October 31, 2014

**Subject: Convenience Store and Fuel Station Development
2282 Congress Street
Amended Site Plan Application
Response to Tom Errico's Review Comments Dated September 17, 2014**

PORTLAND, MAINE CUMBERLAND COUNTY OFFSITE IMPROVEMENTS PROJECT

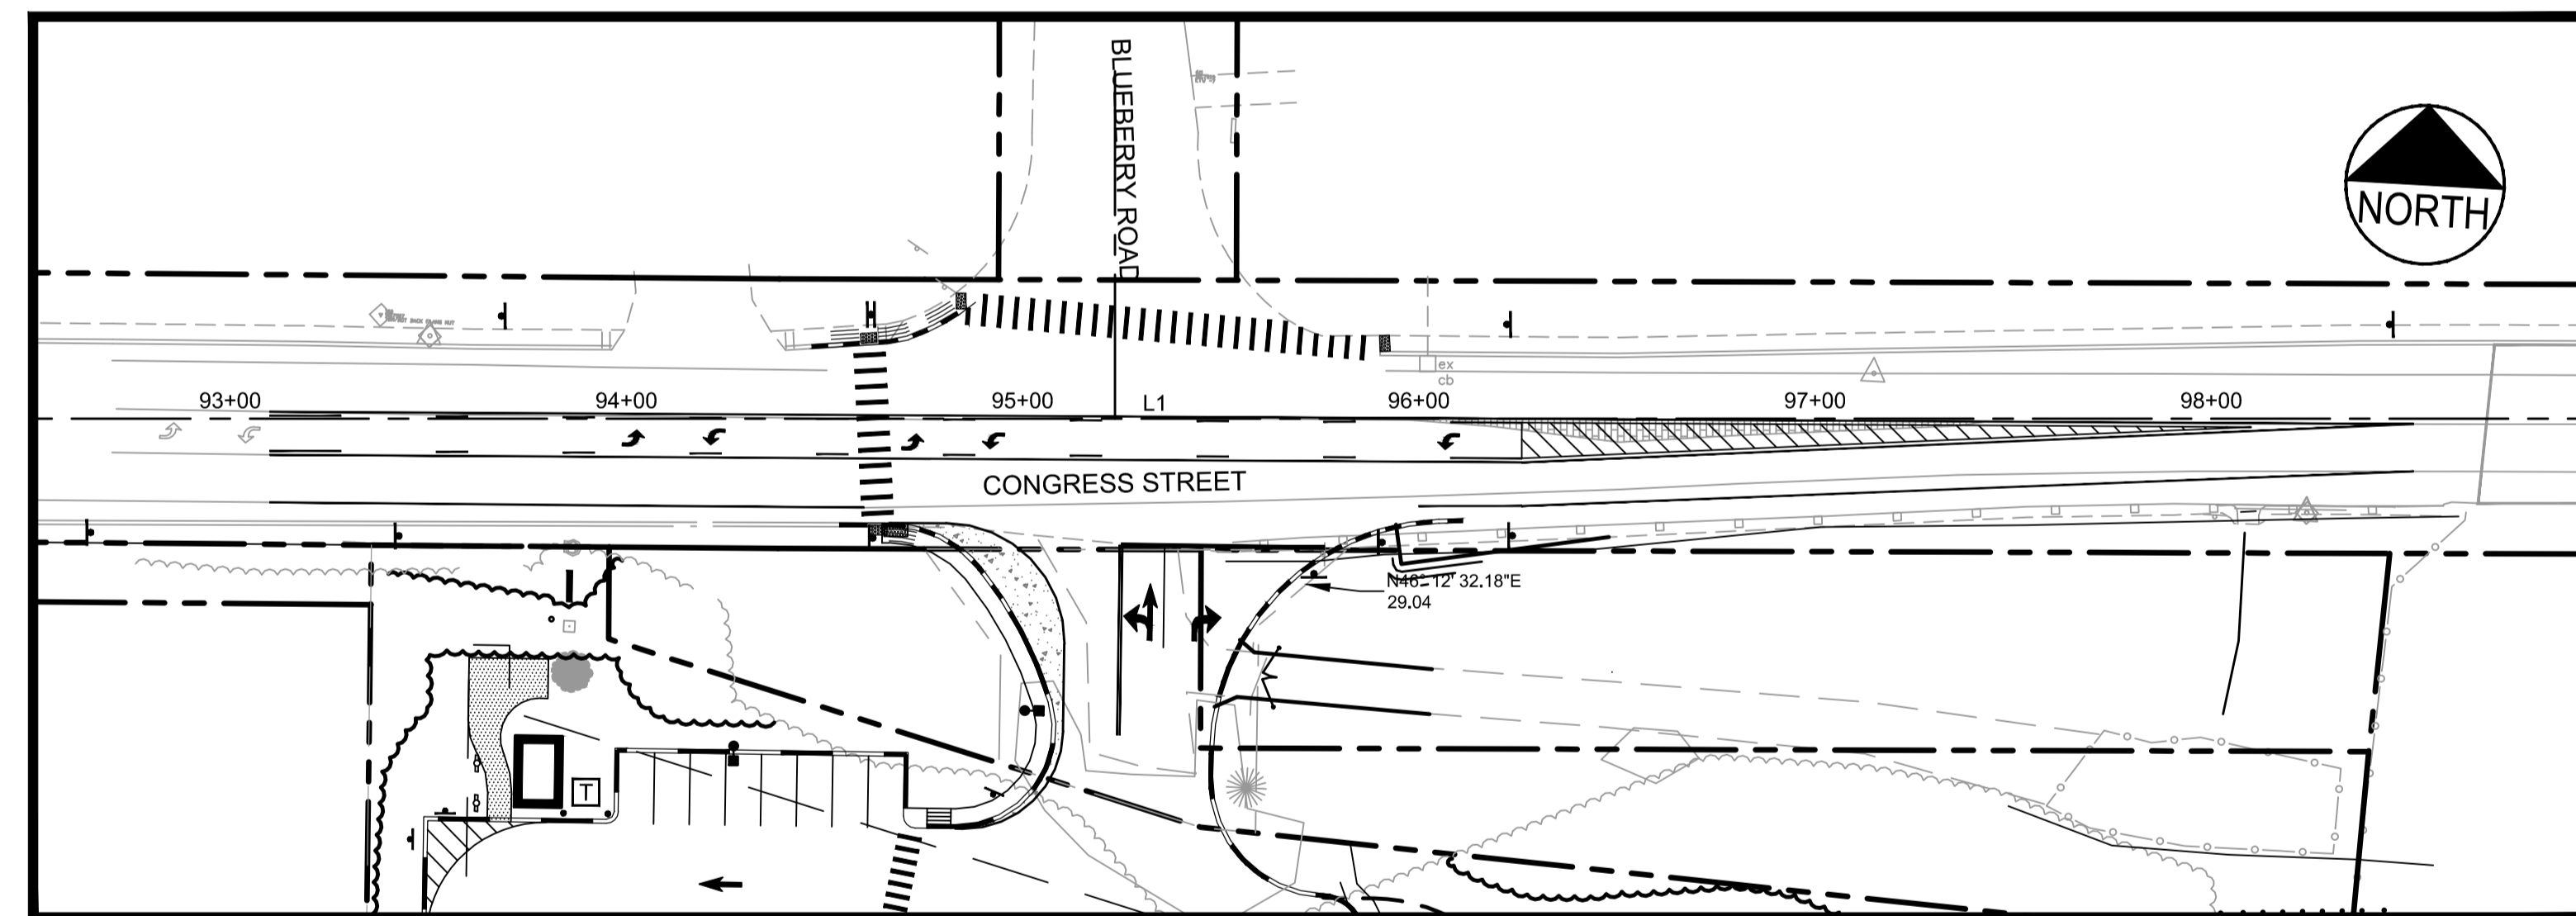
A detectible warning panel shall be installed on the easterly corner of Blueberry Road.

Right-of-way boundaries on the north side of Congress Street should be provided and it should be confirmed that all activity will occur in the public right-of-way.

A detectible warning strip has been added to the plans and reflected on the enclosed Sheet C-4.0 OFF General Improvements Plan and Profile.

The ROW for the north side of Congress Street has been digitized from a plan titled "Maine Turnpike Authority, Maine Turnpike Property and Right-of-way Plan Section 1-Kittery to Portland" by HNTB Dated February 1997. The offsite plans have been revised to include this line.

Sign Package as on sheet C-4.0

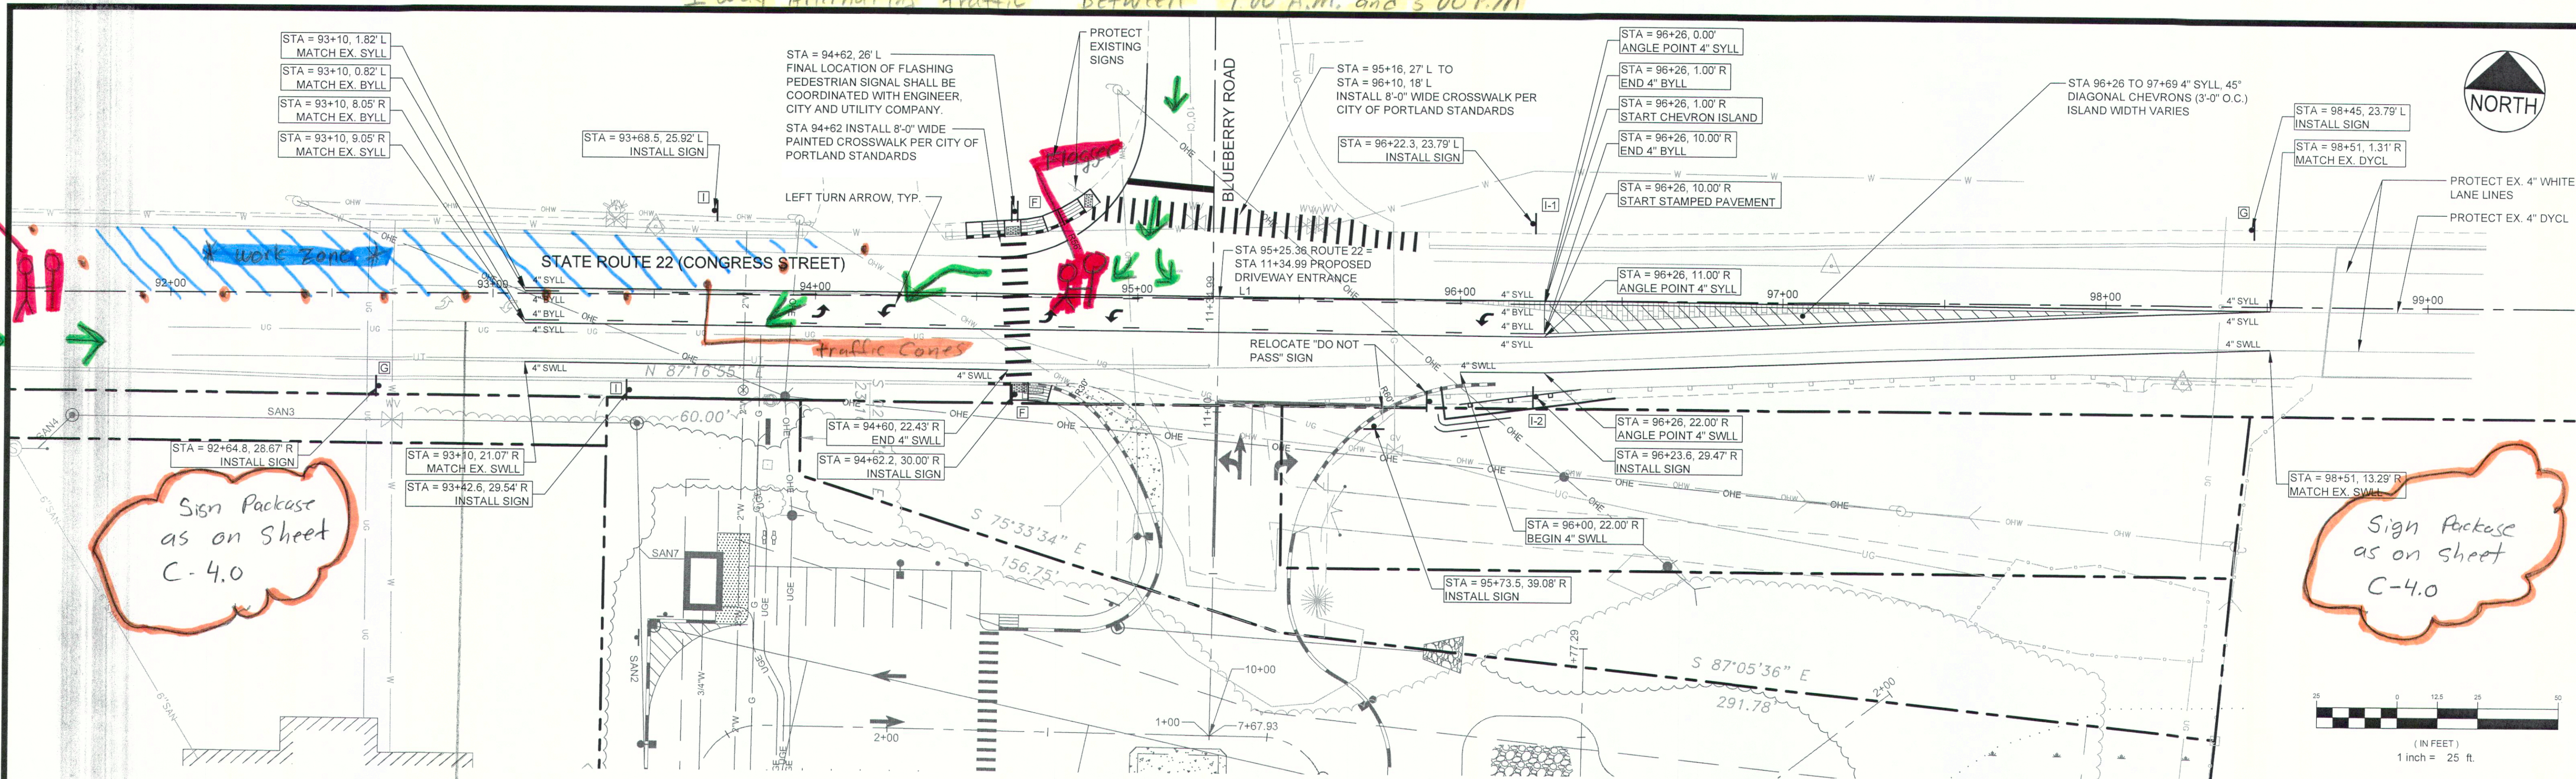
I find the construction plan to be acceptable with the requirement that a variable message board (s) be provided that notes use of Skyway Drive as an alternative route during construction.

The updated construction plan includes signage requirements including variable message boards and enclosed with this letter.
